Application No: 2025/62/93313/E

Address: 68, Oxford Road, Dewsbury, WF13 4EH

Dear Nicole,

Drawing No.
 3665 (0-) 08

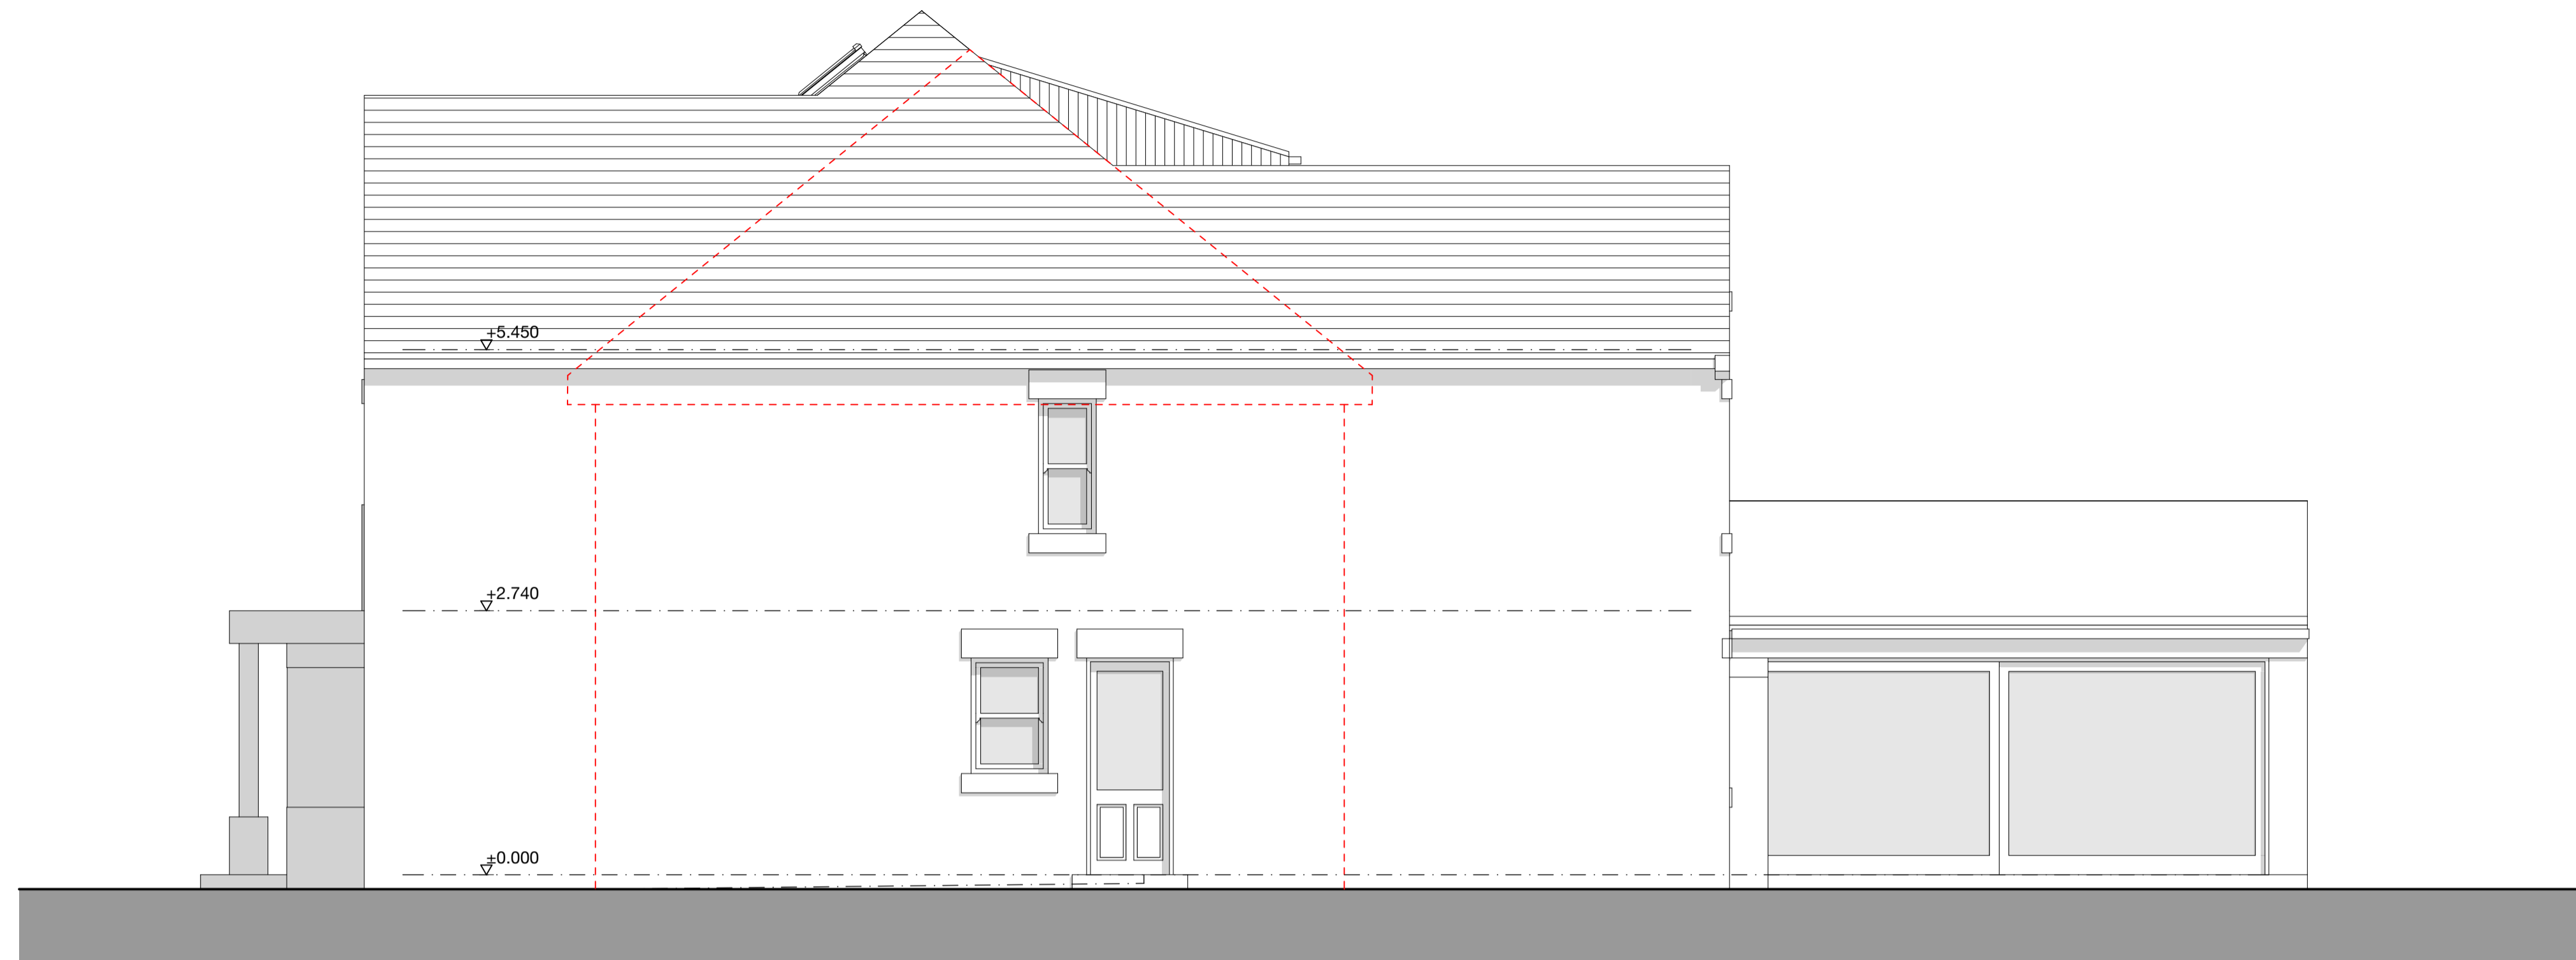
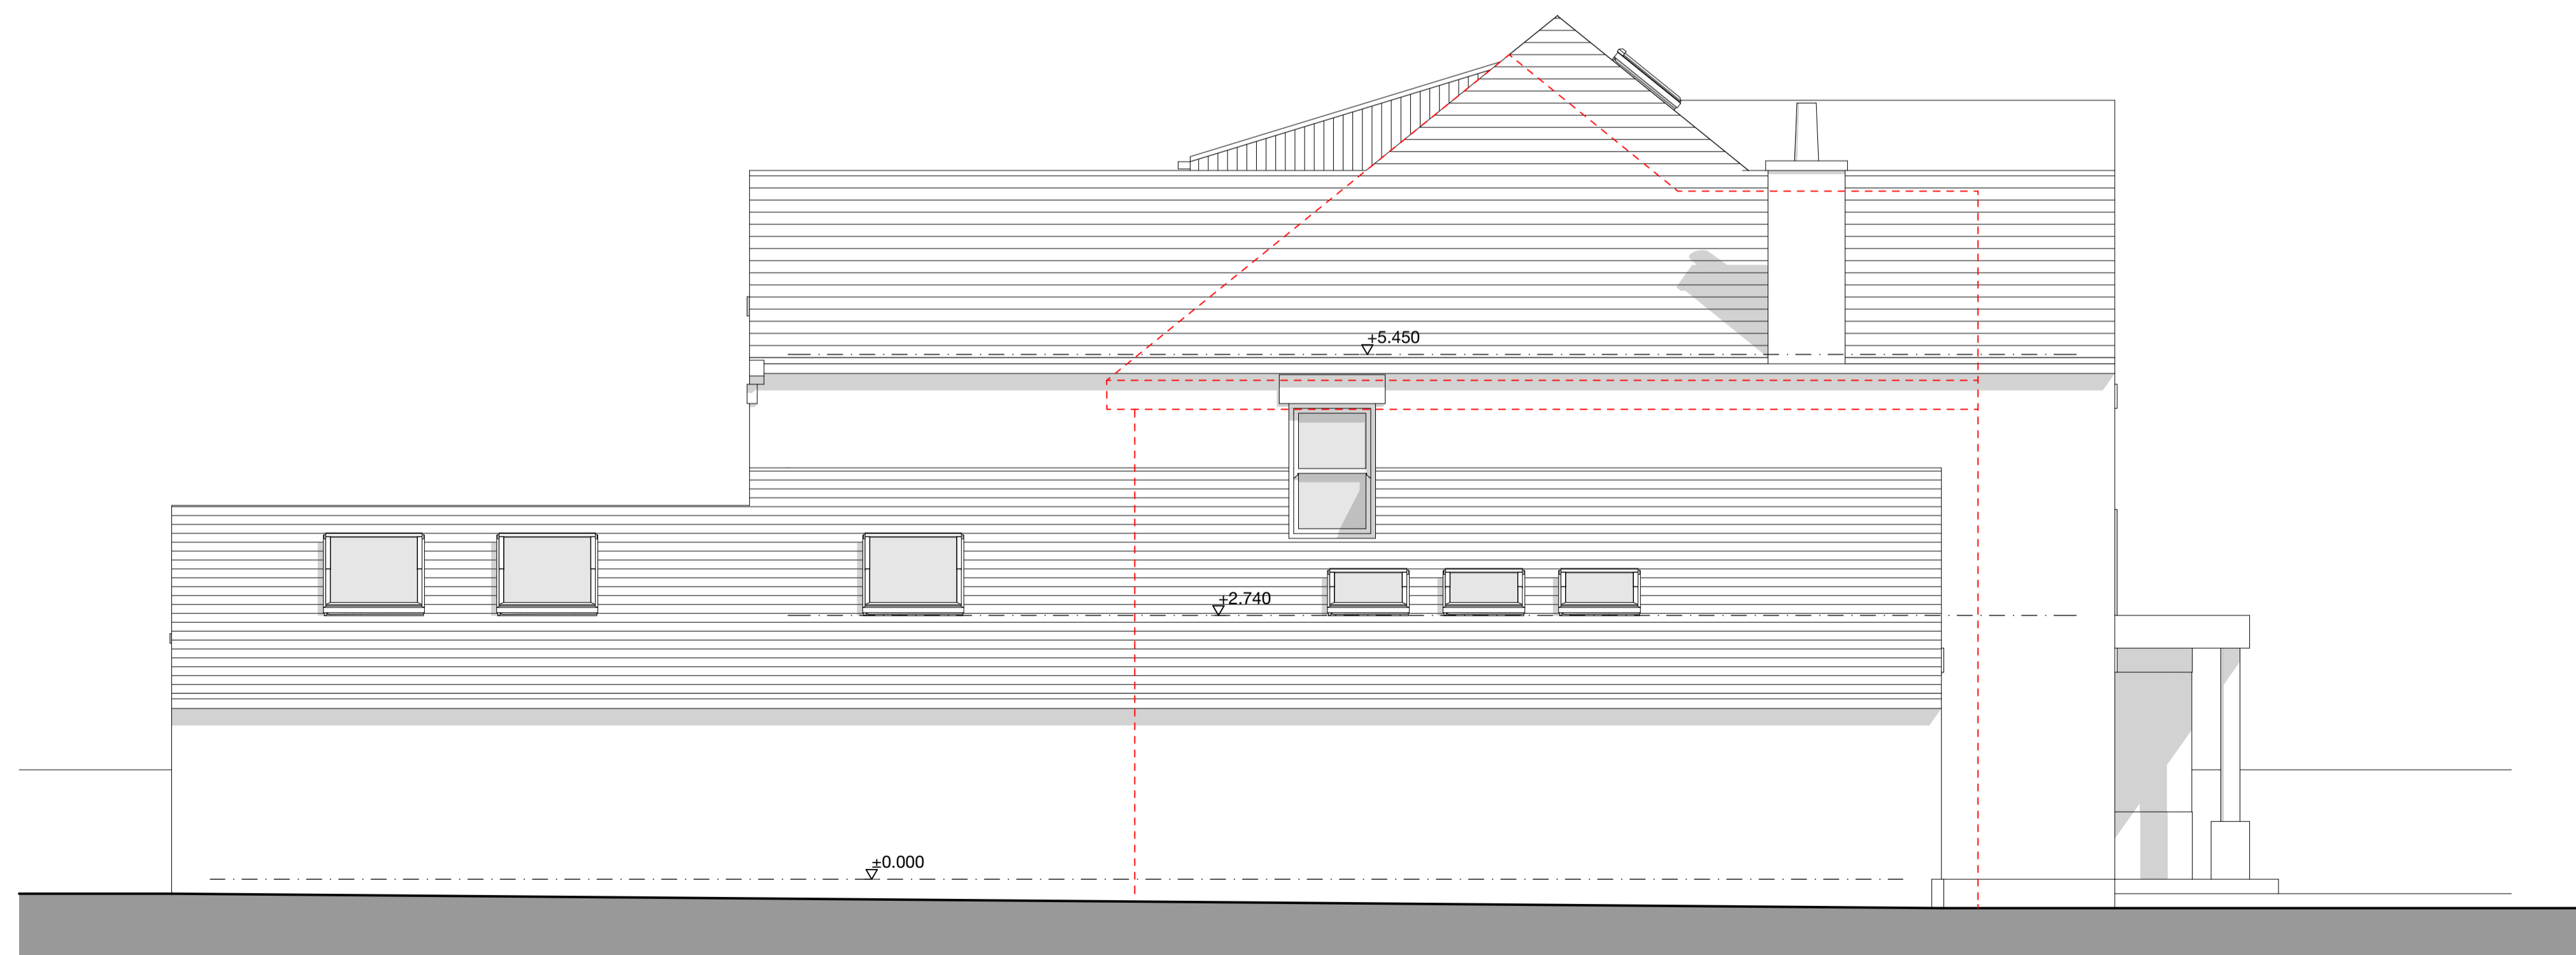
The balconies are elevated and rear-facing, and my property at 2 Reservoir Street sits directly behind the site, meaning the proposals would enable direct overlooking into private rear garden space.

The Planning Statement concludes that the extensions would not be overbearing due to retained distances and roof design. However, this underestimates the impact of the combined height, depth and mass of the rear extensions when viewed from Reservoir Street.
